A47 North Tuddenham to Easton

Scheme Number: TR010038

Volume 9 **9.27 Applicant's Responses to Deadline 6** **Comments**

January 2022

APPENDIX A - Updated Cross-Section Drawings, Originally Submitted With The Applicant's Response To The Examining Authority's Third Written Questions (REP6-018).

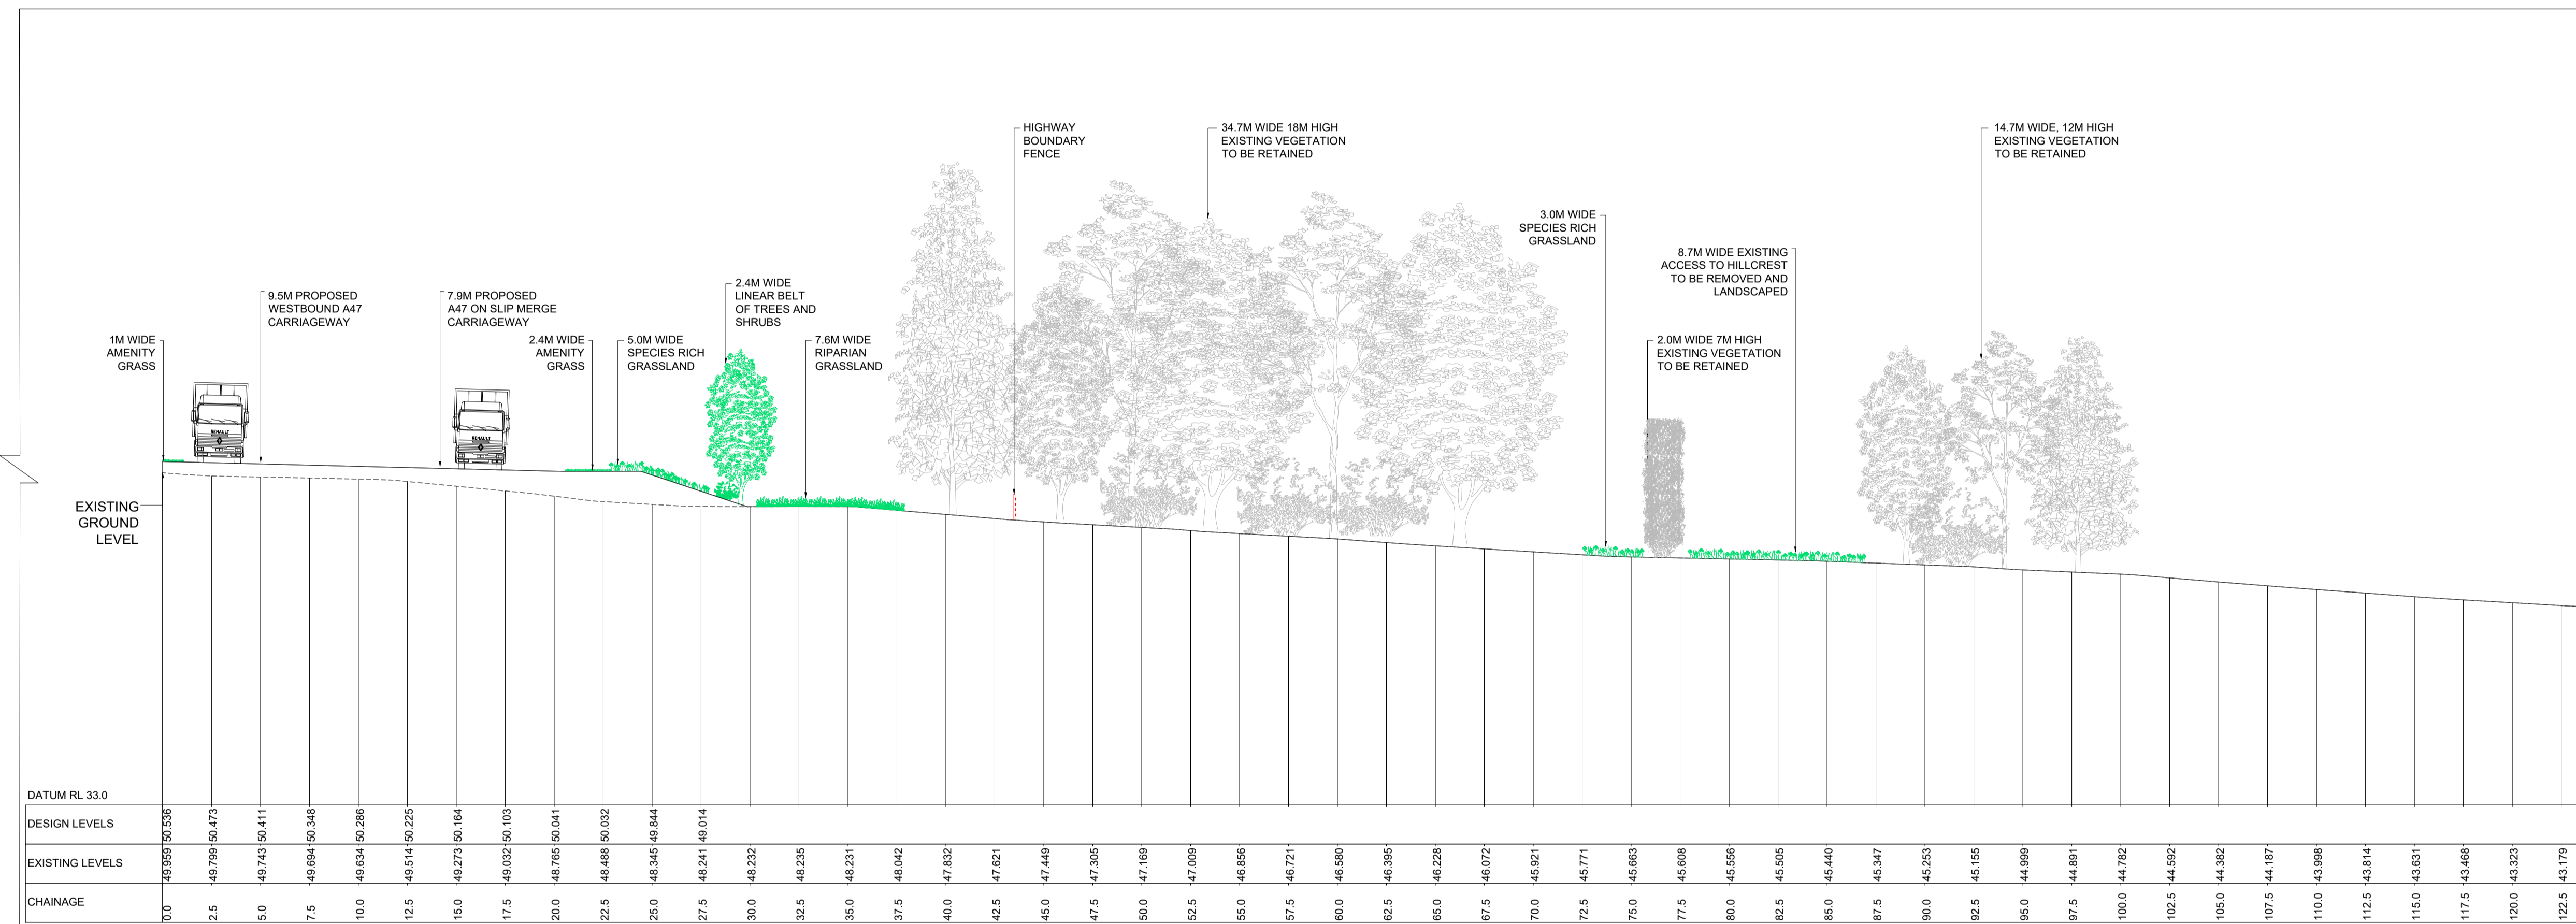
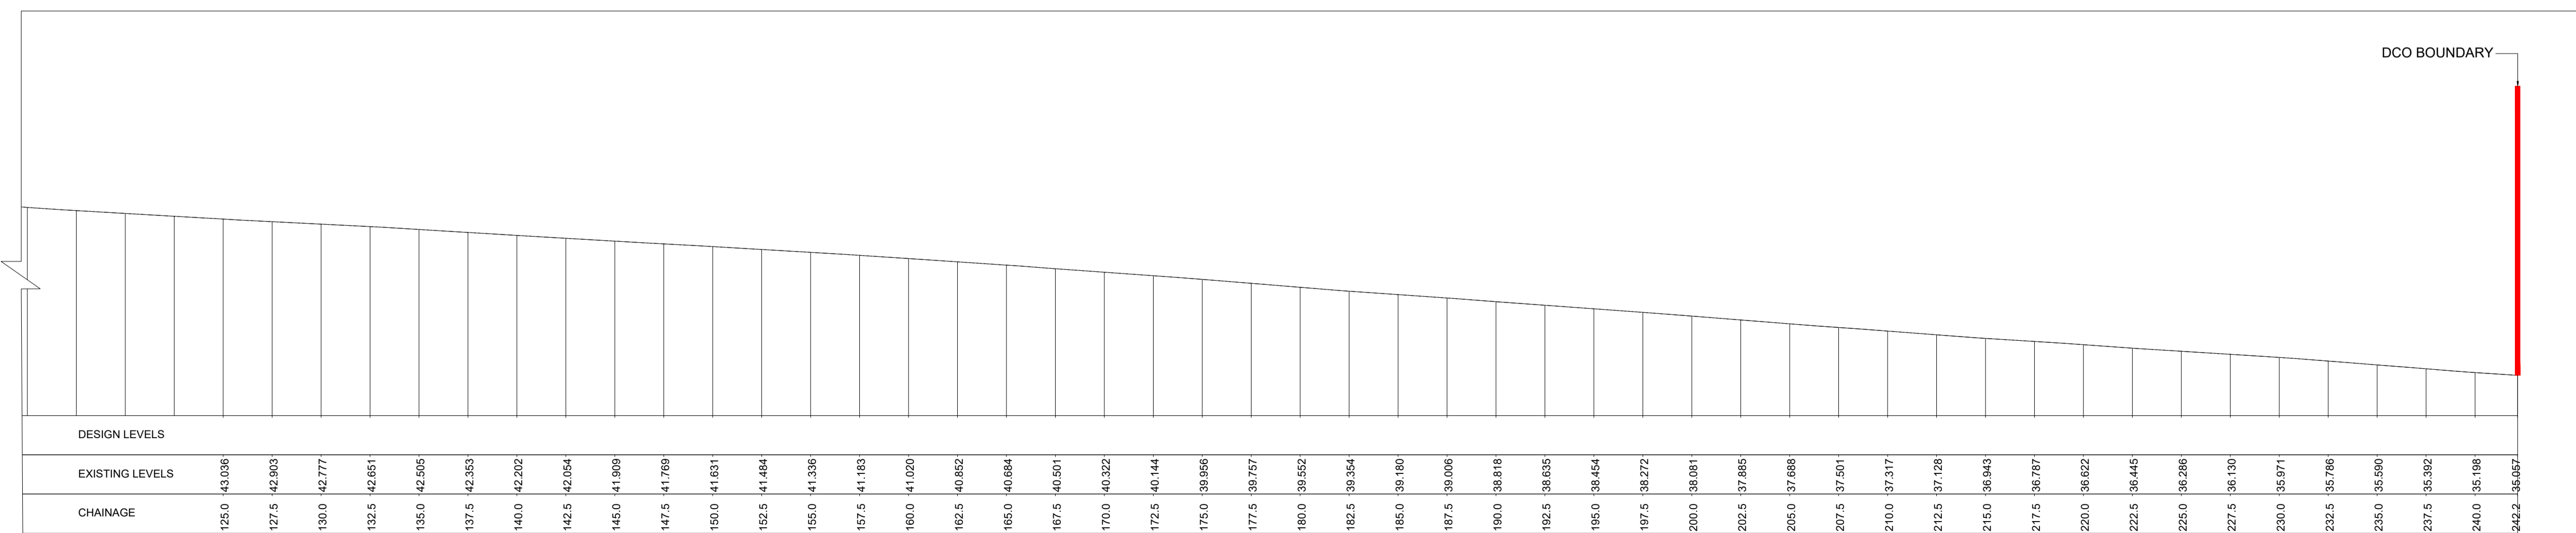
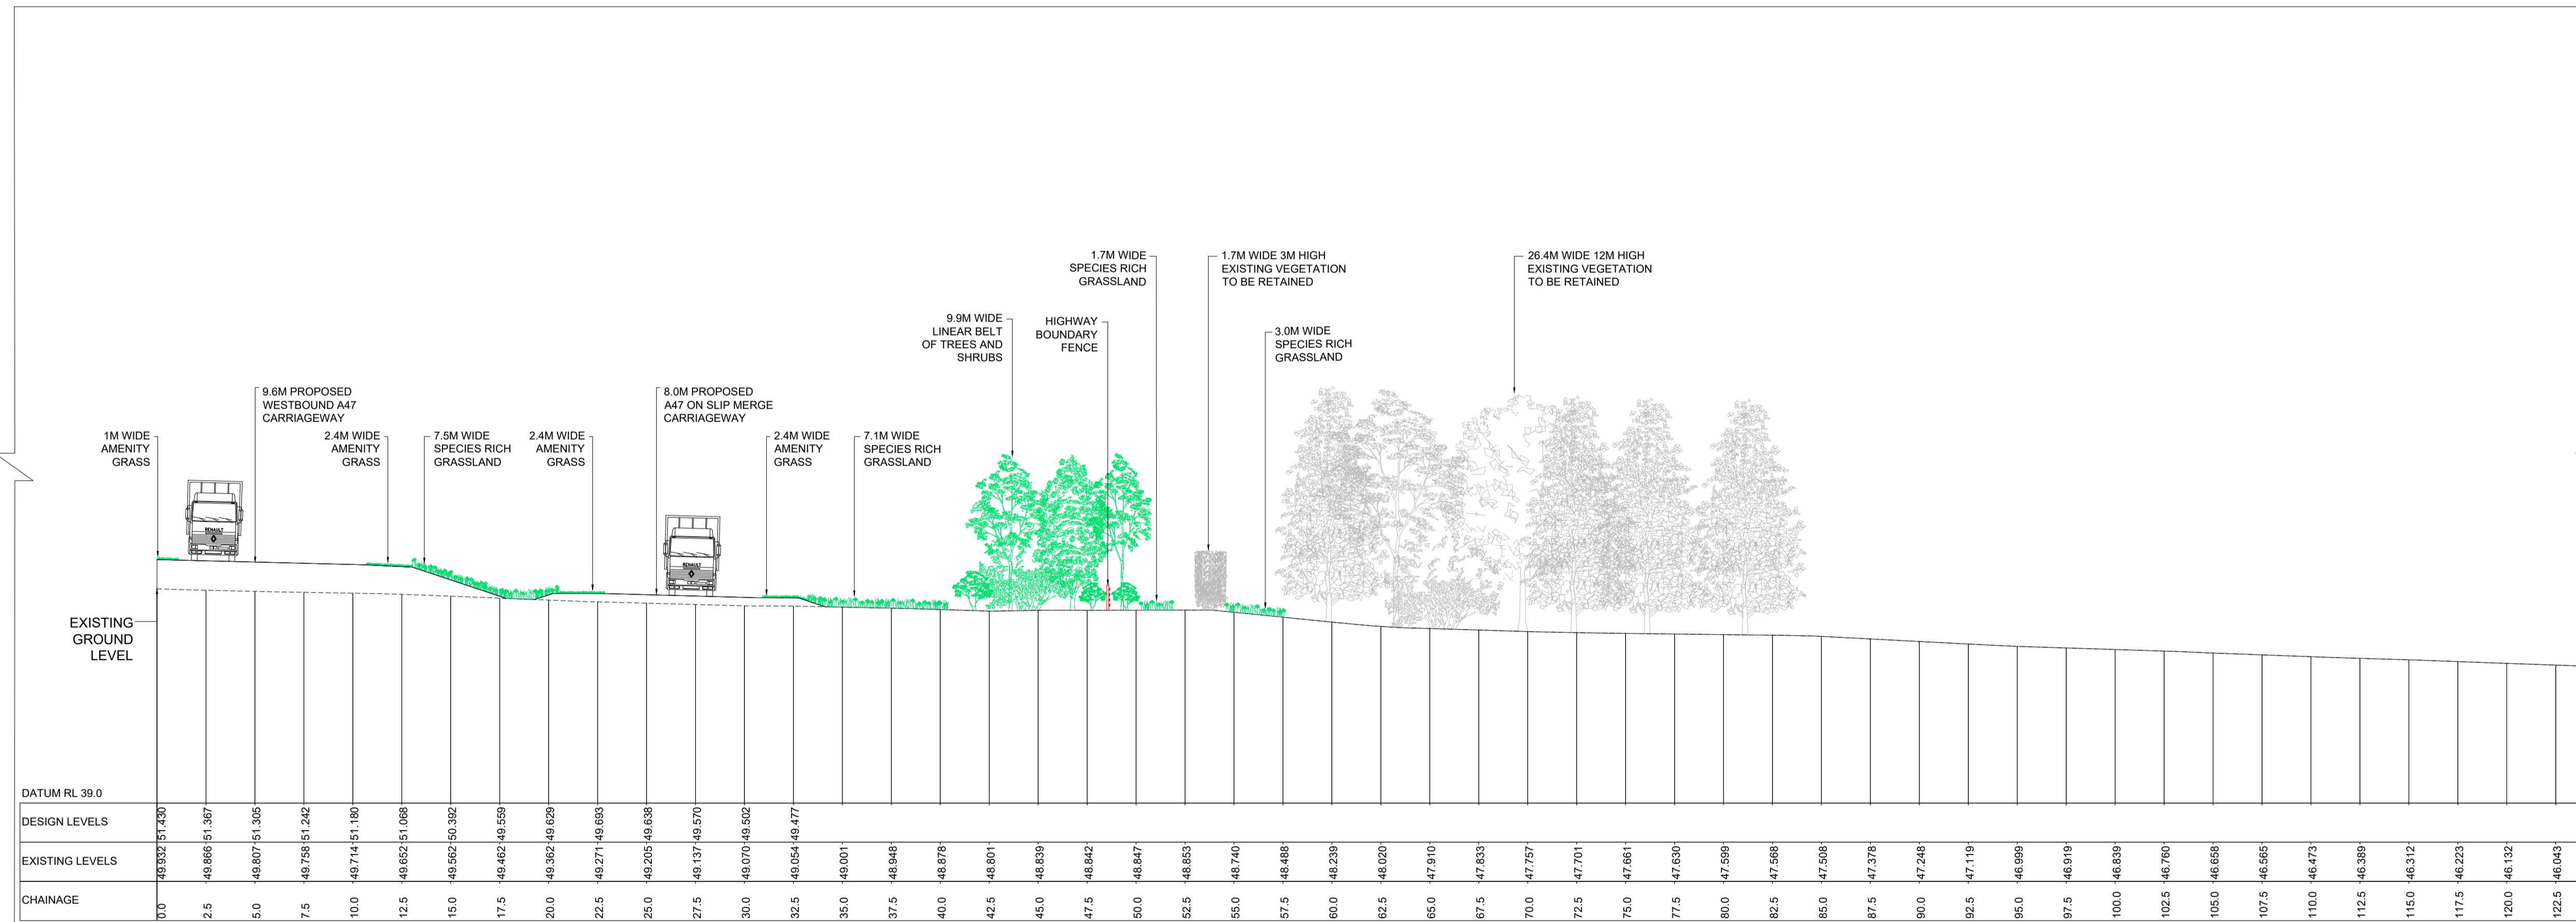
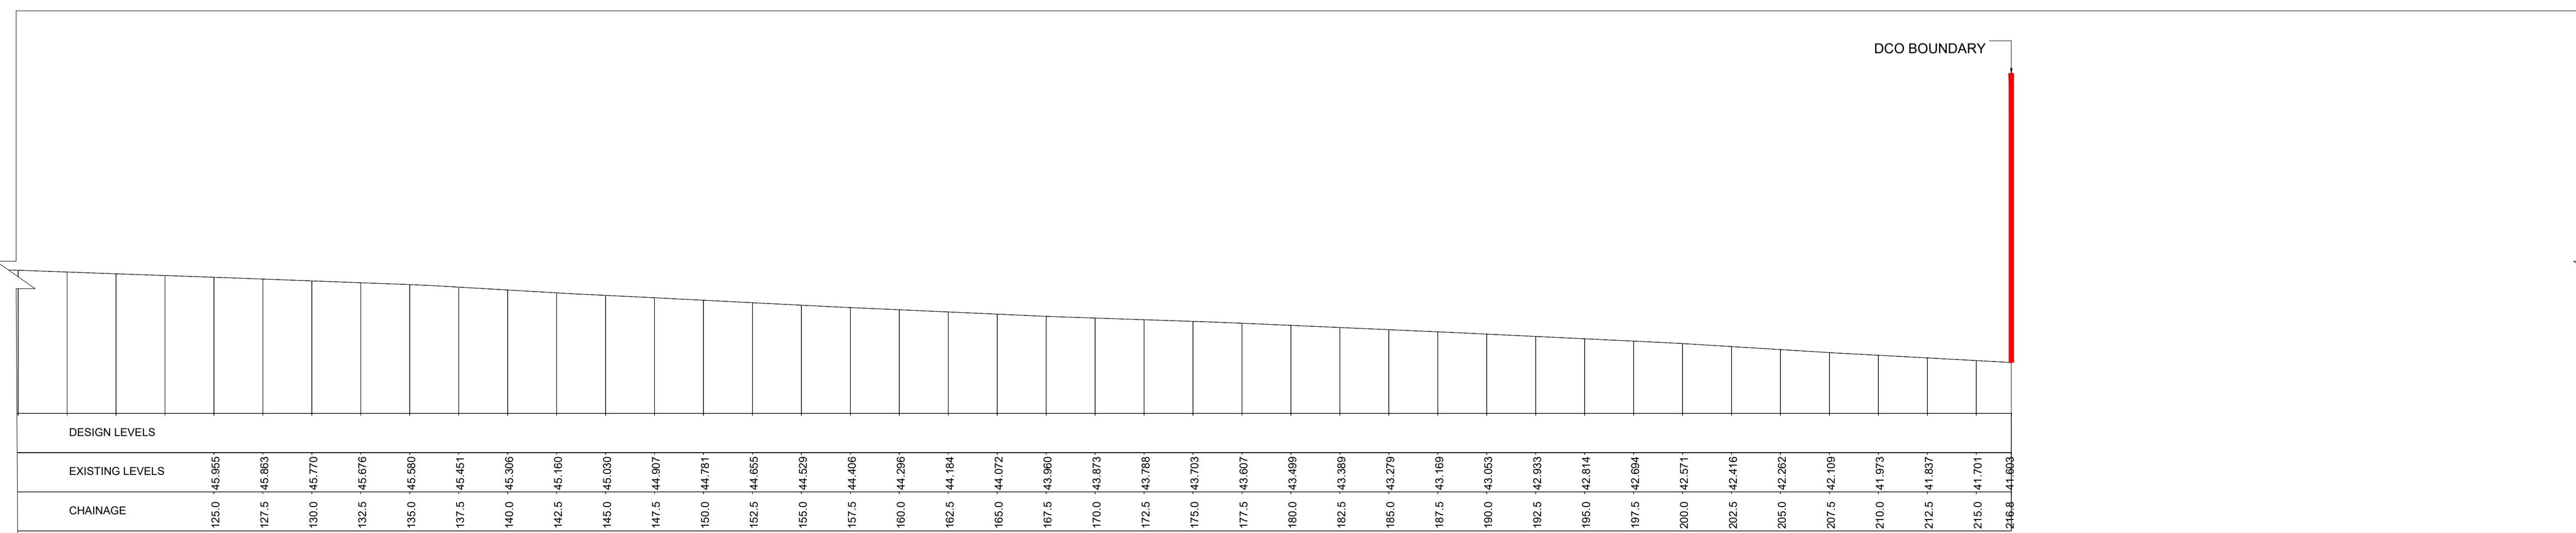
| Comment | Applicant Response |
|--|---|
| <p>5. Heritage. HE is keen to state that the new road will be moved over 200 metres south of the existing A47 and away from properties near St Andrew's Church and the Taverham Road properties. The truth of the statement is actually that whilst the main road itself will be moved away that distance, the new junction to the north and its access roads are only half that distance further south and, crucially, they are being moved into a more direct visual proximity (vertically as well) with the residential properties. Noted that the second plan extract in the HE response did not include the residents that will be almost on axis with the junction.</p> | <p>006).</p> <p>While the mainline is 200m further south of the existing A467, the slip road in between is approximately 115m further south.</p> <p>However, the existing A47 and Taverham Road junction is located approximately 65m south of the River Tud bridge, whilst the northern side of the proposed new junction's northern roundabout is approximately 220m south-west of the River Tud bridge. Most residential properties on Taverham Road lie north of the Taverham Road's River Tud bridge, thus approximately 155m further from the new junction.</p> <p>In addition, as reported in the 'Applicant's Responses to Deadline 4 Comments' (REP5-016), cross sections were provided for the affected properties along Taverham Road. Visual effects identified in Year 15 on properties along Taverham Road are:</p> <ul style="list-style-type: none"> • Neutral adverse (no significant) visual effect on 3 properties at Church Farm (Visual Receptors at R33), on the west side of Taverham Road. • Moderate adverse (significant) effect on views from Viewpoint 7 and from four properties on the east side of Taverham Road opposite Church Plantation (Visual Receptors at R34) during construction and in Year 1 of opening. However, this reduces to slight adverse (not significant) at Year 15 of operation following establishment of mitigation planting beside the Scheme (including tree cover beside the drainage feature directly to the south of the receptor) limiting the visibility to at most glimpsed views. <p>Effects on specific visual receptors are assessed in ES Appendix 7.4 'Visual Receptors' (APP-092) and summarised on Figure 7.5, Rev. 1 (REP2-012).</p> <p>Sheet 14 of the Environmental Masterplan, Rev 2, (REP3-016) demonstrates provision of woodland and shrub planting north of Norwich Road Junction to supplement the retained mature trees north of the existing A47, as shown below, provide a visual screen to properties near Honingham Church and along Taverham Road.</p>  |
